**Consultation Response from KC,
Highways Development Management**

2019/93712 land off, Coniston Road, Meltham, Holmfirth, HD9 4BY

Erection of stables and formation of access track

Date Responded: 20/12/19 | Responding Officer: J Turner | Responding Ref: K3-14/1

CLIENT			
MR NIGEL DYSON			
PROJECT			
PROPOSED STABLE BLOCK CALMLANDS MELTHAM			
DRAWING TITLE			
PROPOSED SITE PLAN			
Rev.	Notes	Date	Drawn
SCALE	1:200@A1	11.19	A.D.
PROJECT No.	DRAWING No.	Rev.	
1971	01	-

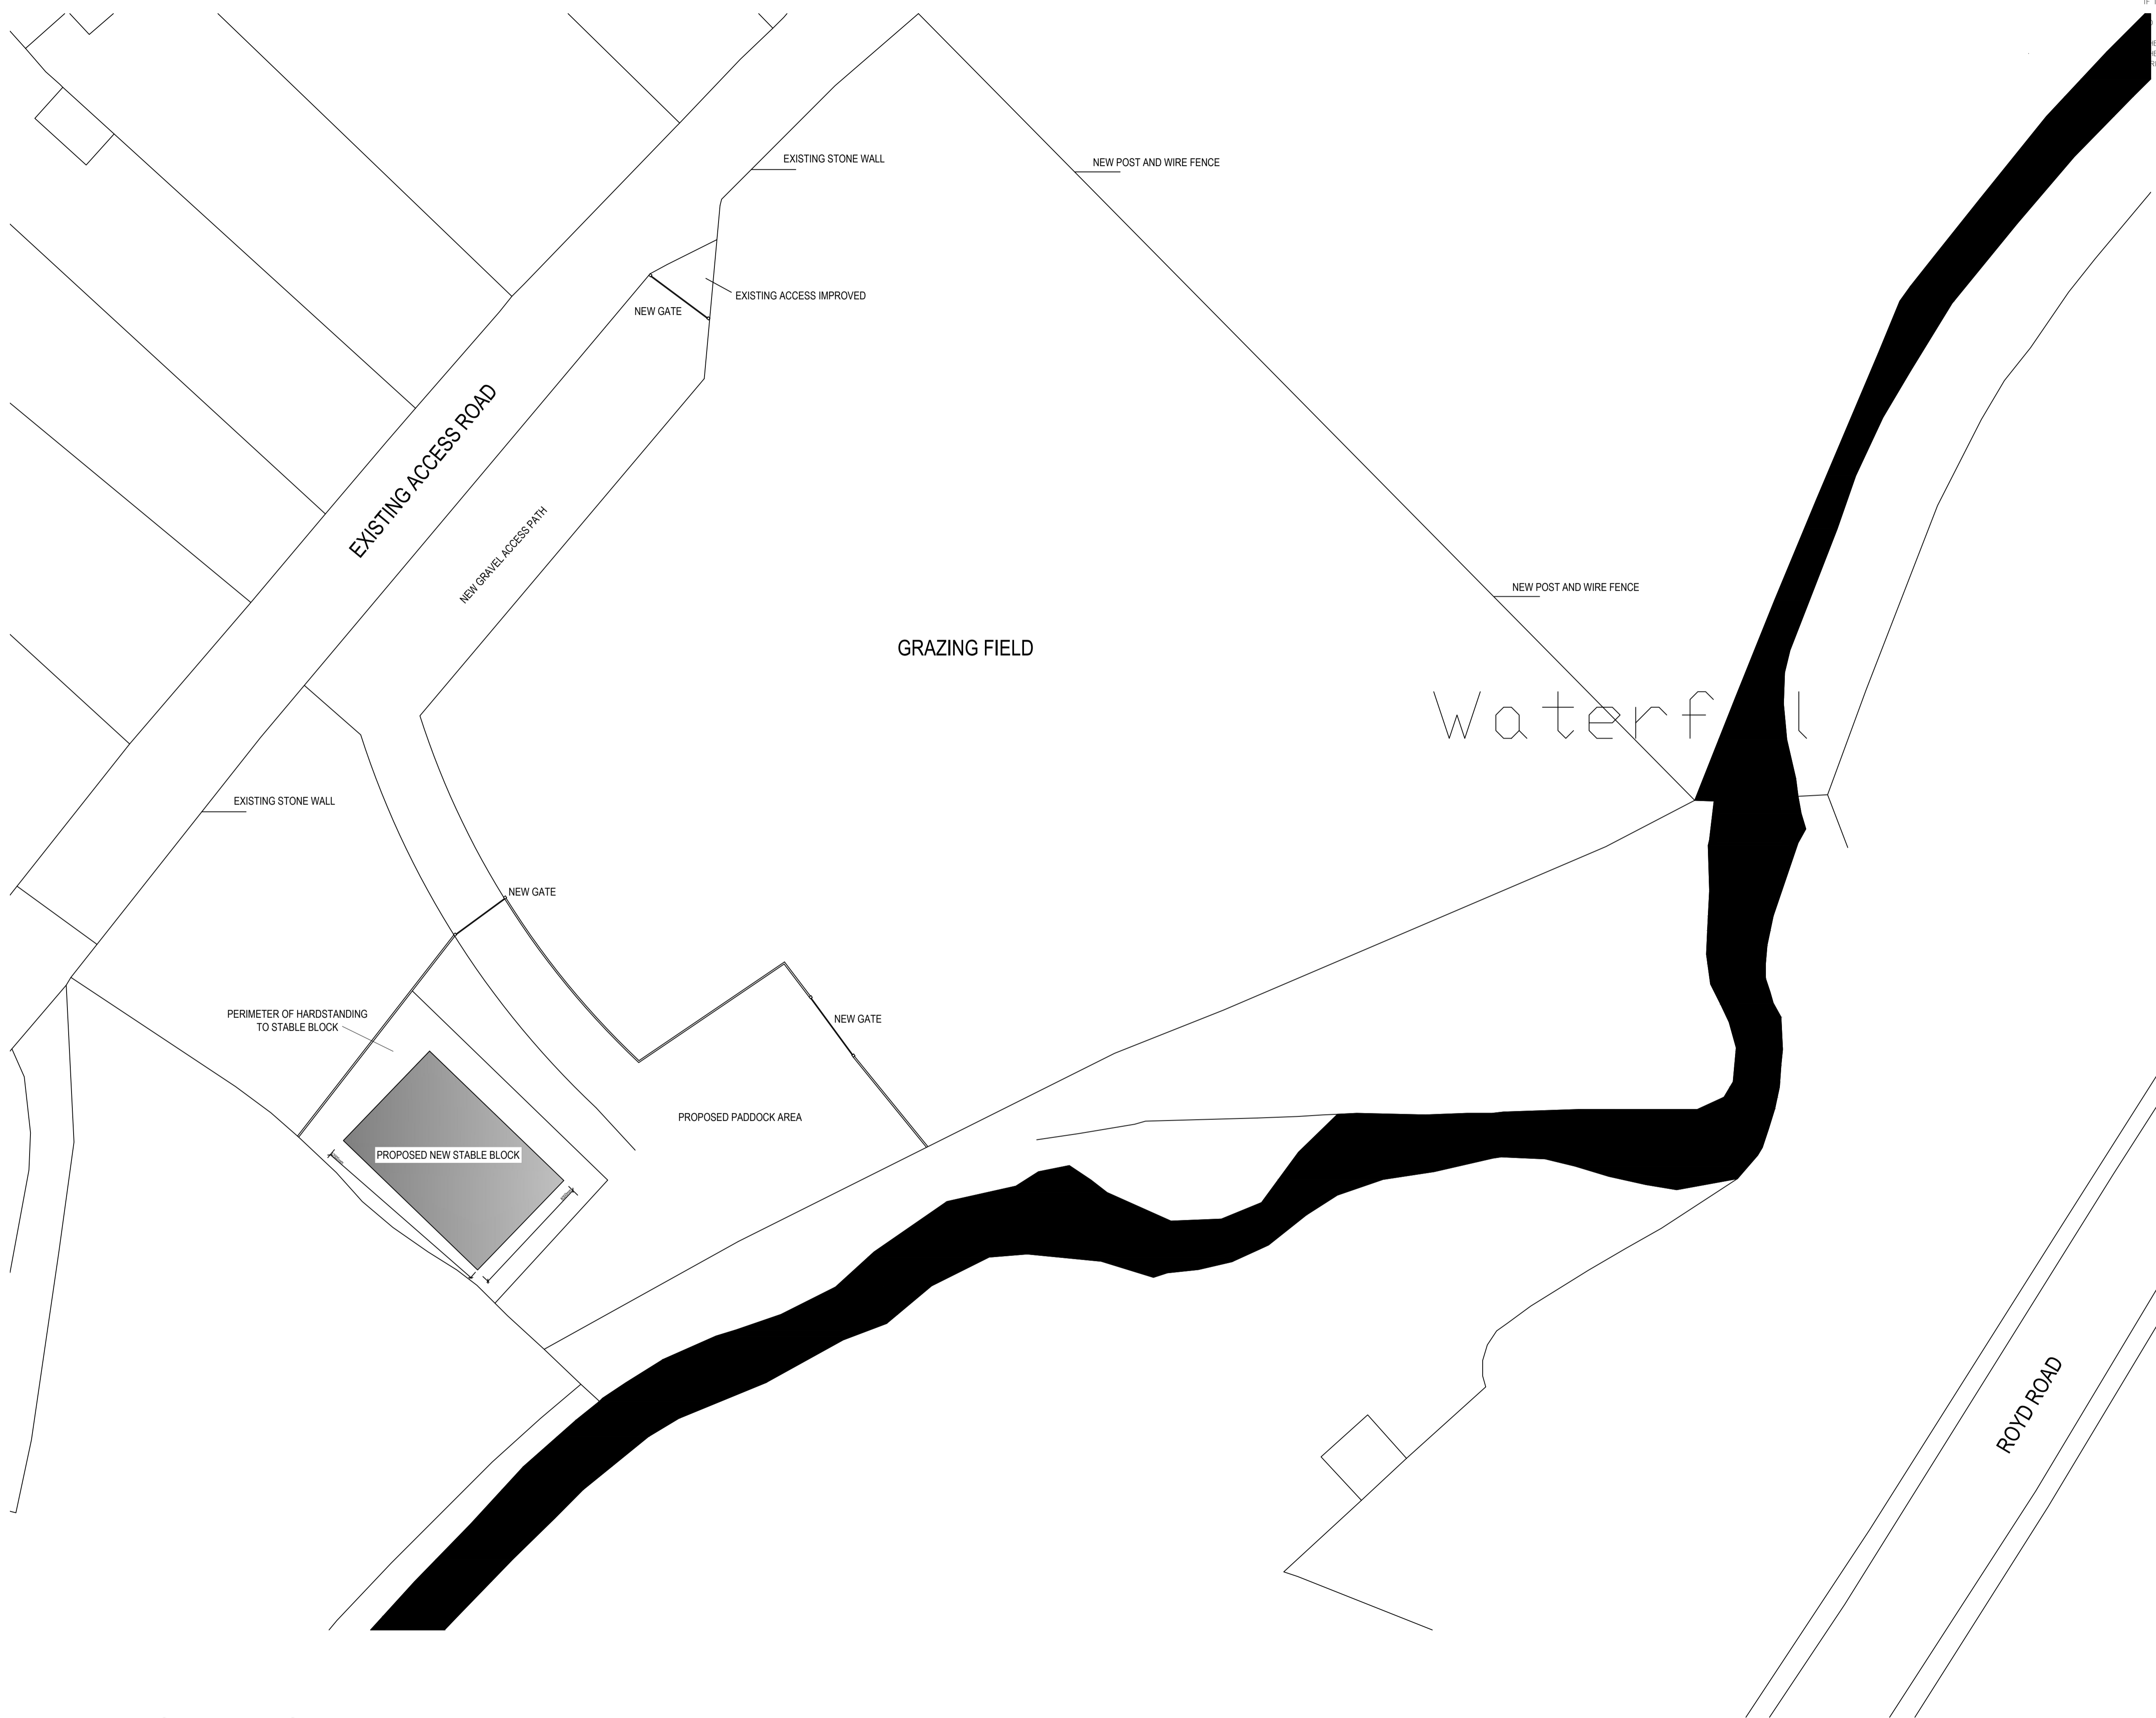
The proposal would consist of four stables units, a tack room, and a feed store, it would be served by a newly-formed track taken off an existing access road that meets the public highway at Holmfirth Road. Approximately the first 145m of the track forms part of Public Right of Way no. MEL/43a/10.

The access is wide enough to allow two vehicles to pass easily, although it is in a state of disrepair in some sections. This application is likely to intensify the use of the track, so Highway DM would request some remedial measures to improve the condition of this access.

The scheme is acceptable from a highways perspective. Please add the following conditions to the decision notice:

Areas to be surfaced and drained

Prior to the development being brought into use, the approved vehicle parking areas shall be surfaced and drained in accordance with the Communities and Local Government; and Environment Agencies 'Guidance on the permeable surfacing of front gardens (parking areas)' published 13th May 2009 (ISBN 9781409804864) as amended or superseded; and thereafter retained throughout the lifetime of the development.

Defects Survey

The development shall not commence until a survey of the existing condition of the existing access has been submitted to and approved in writing by the Local Planning Authority. The survey shall include carriageway and footway surfacing, verges, kerbs, edgings, street lighting, signing and white lining. Upon completion of the development and before any building is brought into use a highway condition survey identifying a scheme to reinstate any subsequent defects in the condition of the access between the site and Holmfirth Road shall be submitted to and approved in writing by the Local Planning Authority.

All of the identified works shall be implemented before any part of the development is first brought into use.
